# CITY OF ALBUQUERQUE

**Re: Valley View**  
**9368 Valley View Drive NW**  
**Traffic Circulation Layout**  
Architect's Stamp 07-06-2021 (C13-D036)

Based upon the information provided in your submittal received 07-08-2021, the above referenced plan cannot be approved for Building Permit until the following comments are addressed:

1 Site Plan - Proposed
Scale: 1" = 20'-0"

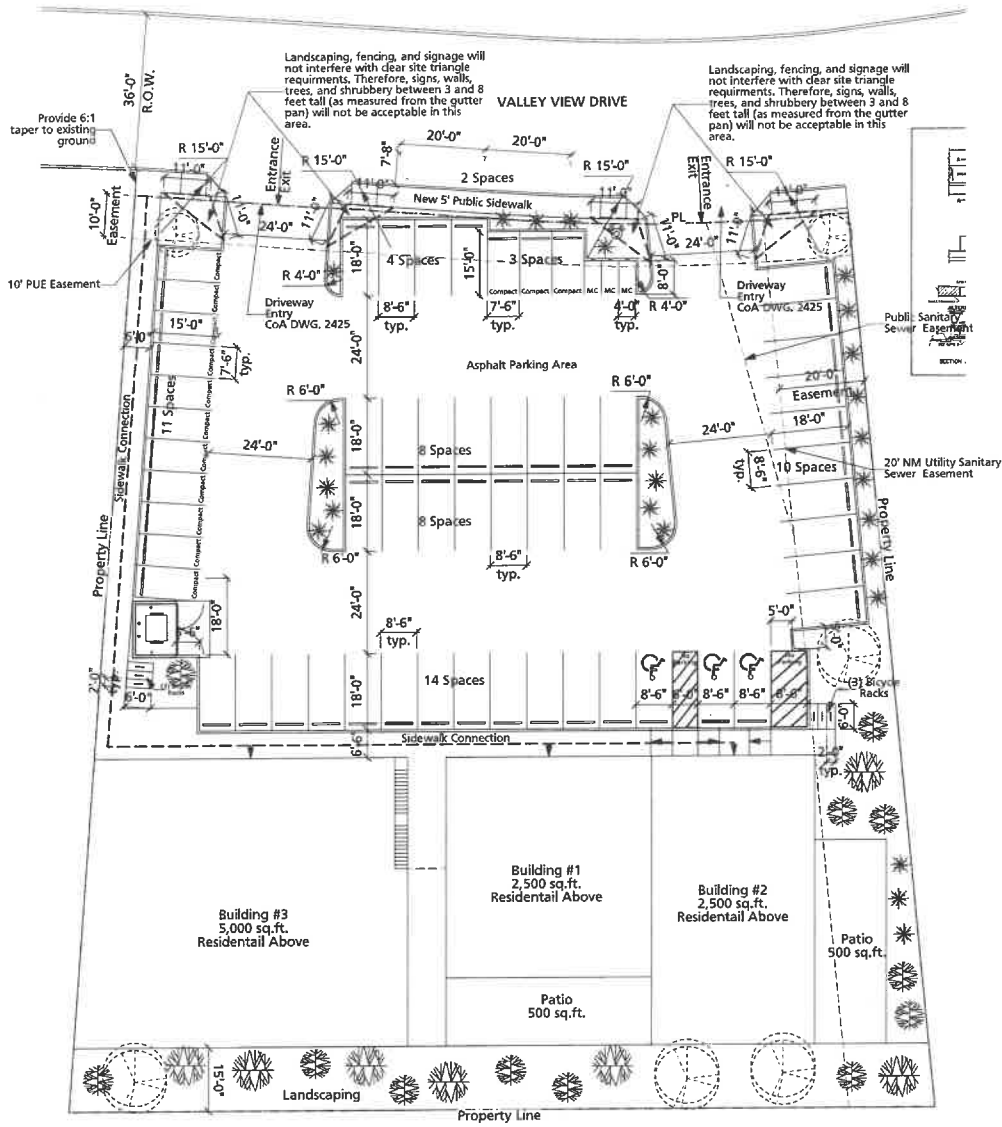
2. **Standard Curb/Gutter Detail provided on site plan.** Please remove the word and 2415A from Standard from the provided detail title because City standards call out Standard c&g as 8" and you call it out as 6". I understand that this type of curbing is being used on site and not on public frontage since there appears to be curb and gutter existing. Now if detail not being used on internally then the detail will need to be adjusted and another detail will need to be provided for internal site curb and gutter.

3. Identify all existing access easements and rights of way width dimensions.
4. Identify the **right of way width**, medians, curb cuts, and **street widths** on Valley View Drive.

6. The ADA accessible spaces must include an access aisle. Van accessible aisles should be 8ft wide; **all others should be 5ft wide.**
7. **Valley View Drive:**
  - ADA curb ramps must be updated to current standards . **Provide detail per COA standard requirements.**
  - Provide detail or call out **COA std dwg number for this type of ramp detail.**

- You have provided 2 parking spaces on this street frontage. **Please provide dimensions for these stalls.**

12. Listed are radii's for all curves shown; for passenger vehicles. **Radius for delivery trucks, fire trucks, etc. is 25 ft. or larger. Please provide FD approval.**

13. A 5 ft. keyway is required for dead-end parking aisles.
14. Per the IDO, a 6 ft. wide ADA accessible pedestrian pathway is required from the public sidewalk to the building entrances. **Please clearly show this pathway and provide details.**

15. Per DPM, a 6 ft. wide ADA accessible pedestrian pathway is required from the ADA parking stall access aisles to the building entrances. Please clearly show this pathway and provide details. **Do you need ramps to accommodate the required 6ft ADA accessible pedestrian pathway?. It appears that this is the condition to be addressed.**

16. ADA accessible pedestrian pathway should not be placed behind parking space or adjacent to a vehicular way. **Vehicle and pedestrian/wheel chair conflicts should be avoided as much as possible.**

17. All **NEW** sidewalks along **Valley View Drive:**
  - should be **placed at the property line.**
  - West end of sidewalk add **note to provide 6:1 taper back into existing ground surface elevation.**

- Build **5ft sidewalk per COA std dwg 2430.**
  - You show a **Standard Sidewalk Detail** but still need to reference 2430.
18. **Parking areas shall have barriers to prevent vehicles from extending over public sidewalk, reducing the required 6 ft ADA pathway to building entrance.**

19. Provide a copy of refuse approval.
20. It is not apparent what type of pavement surface is being proposed. A hard driving surface will be required as part of this proposed project for parking area and drive aisles.
